Permit Number: 030007

This is to certify that Harris Rudolph L. &/Maine
has permission to Adding 24' x 22' attached garage with 6' curb, driveway and hipped roofing.
AT 30 Aldworth St 309 H005001

Proposed Project Description:
Adding 24' x 22' attached garage with 6' x 6' breezeway and house roofing.

Scale: 1/8" = 1'-0"	Approved by: _____
Date: 12-21-02	Drawn by: J.C.
Drawn for: H.R.P.S.	Checked: _____
Location: RICHMOND, M.E.	Project: 14

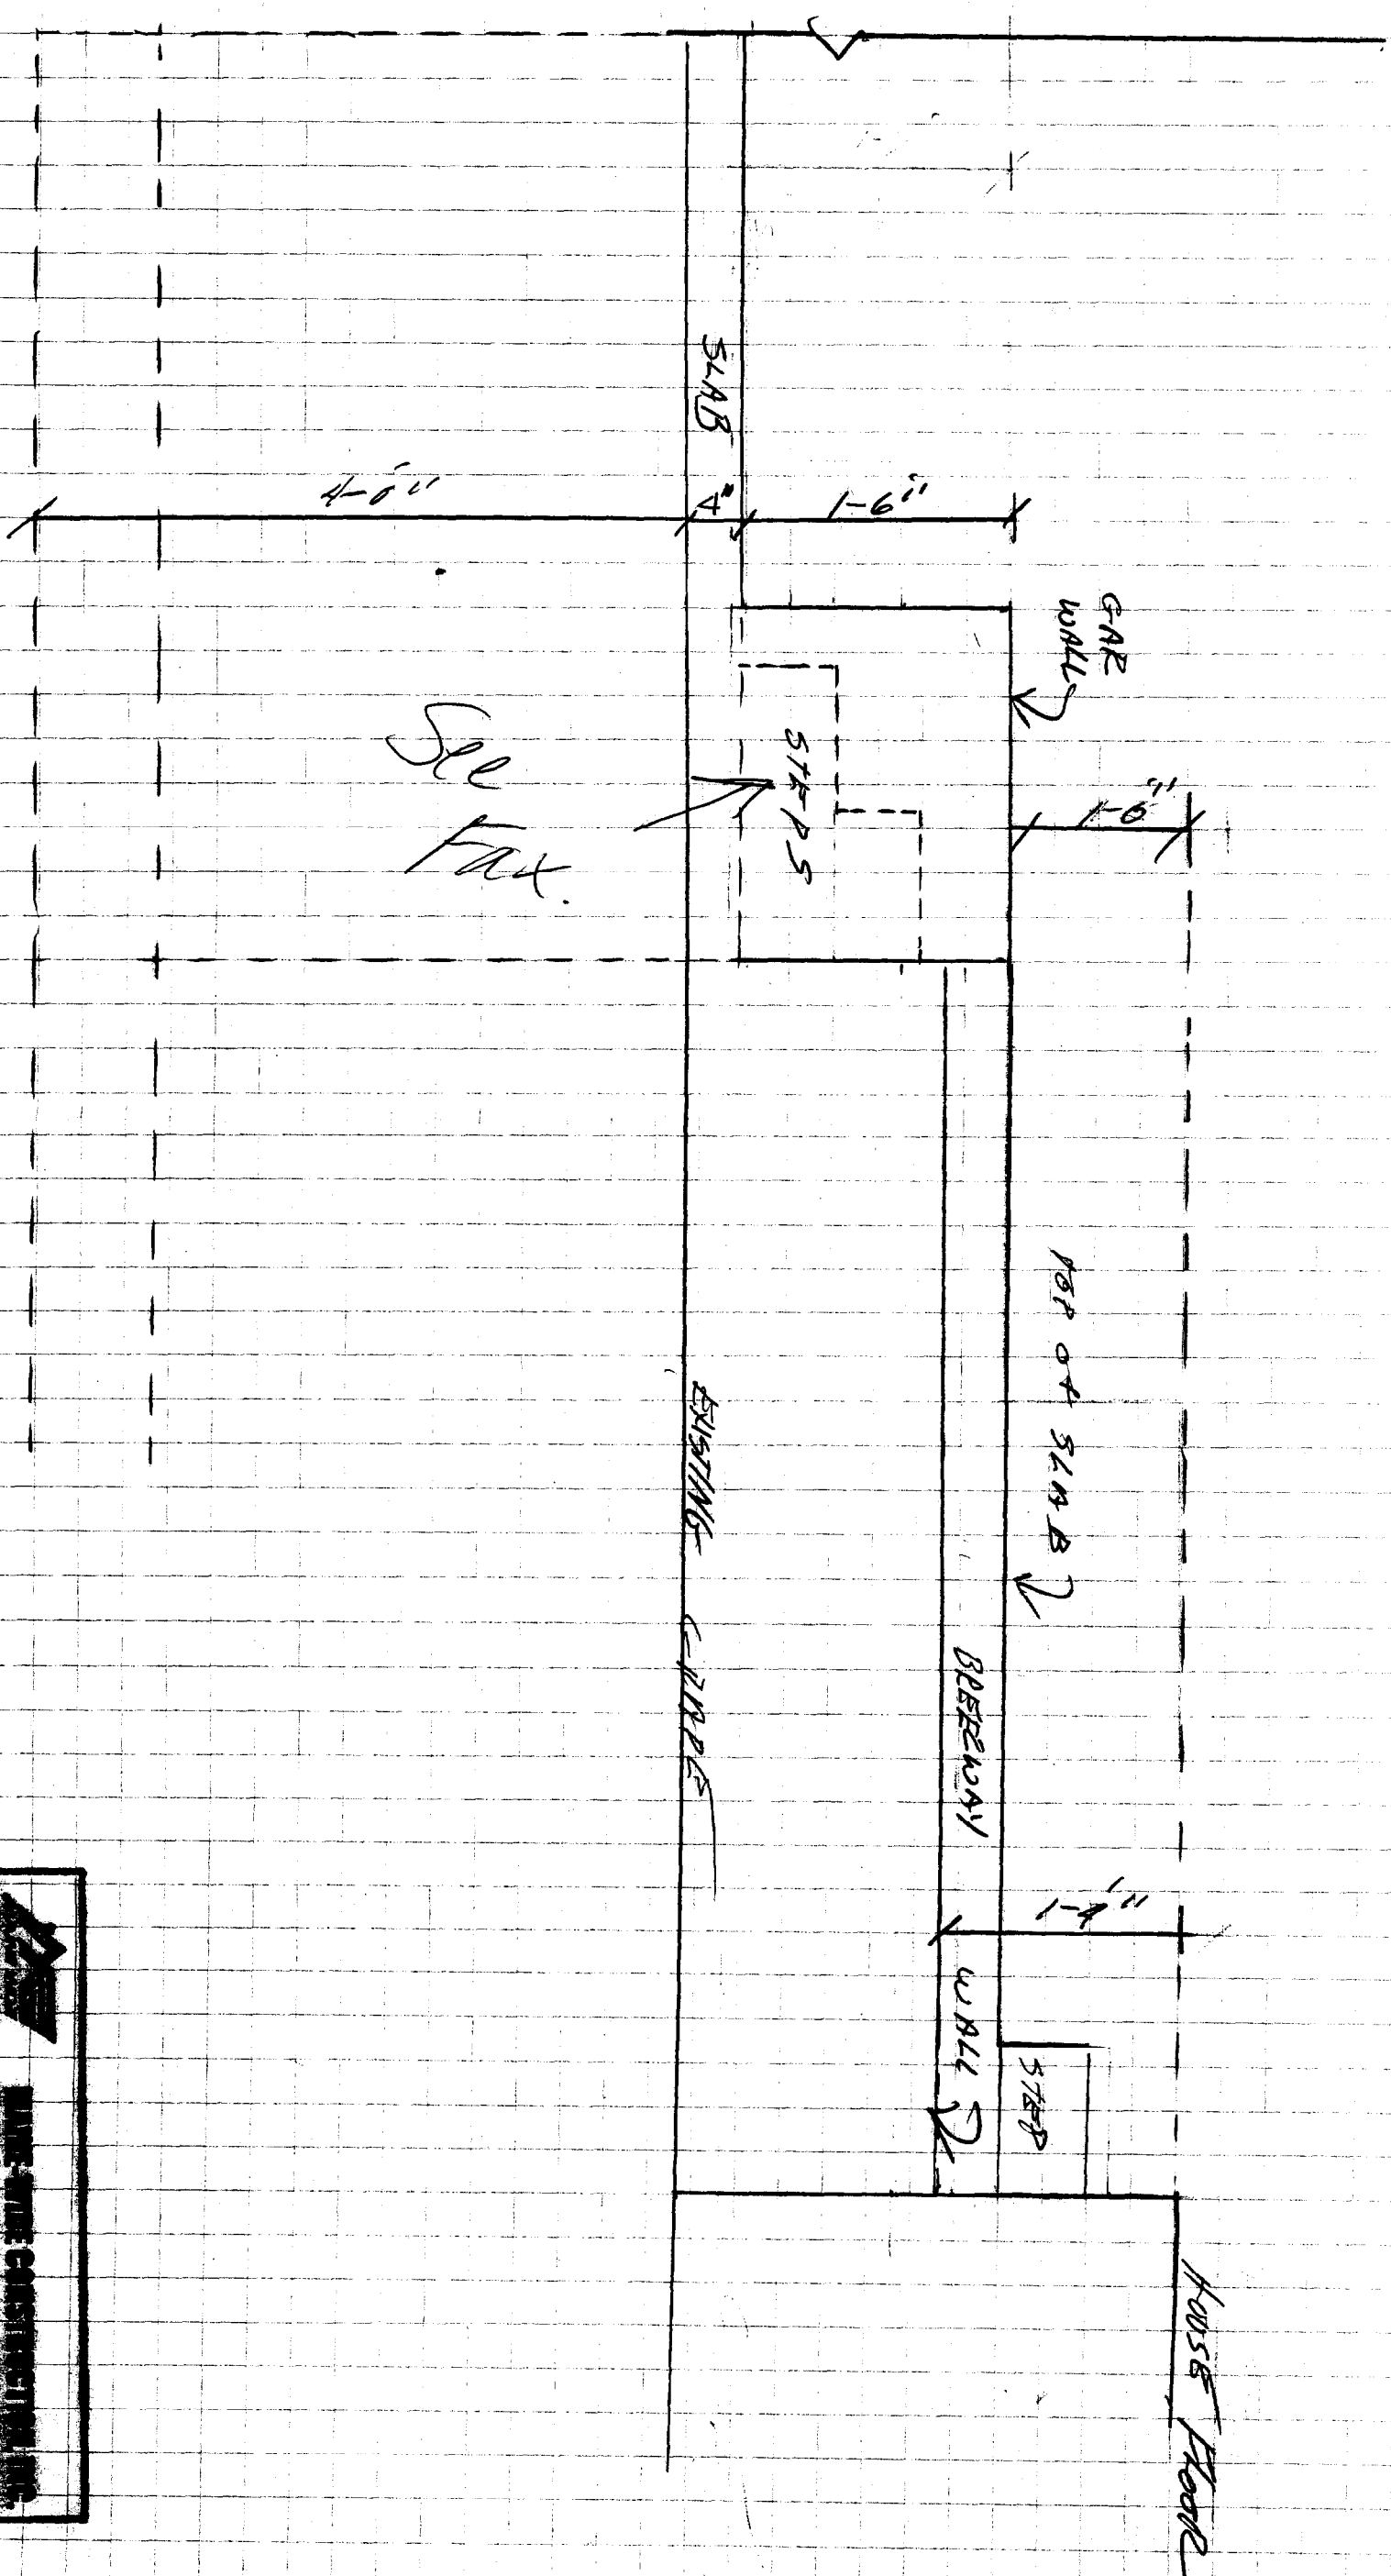
1/17/03-tm: Proposed structure exceeds maximum allowable lot coverage. Also, headers undersized over garage doors, tread and rise not indicated on stairs, no guards shown on stairs., roof sheathing not shown. Called Tina Marie @ Maine Wide.

- OHD headers = 2-LVL beams 3-1/2 x 9-1/2 x 9'-6"

- Steps to be no more than 7-3/4" rise & full 10" step
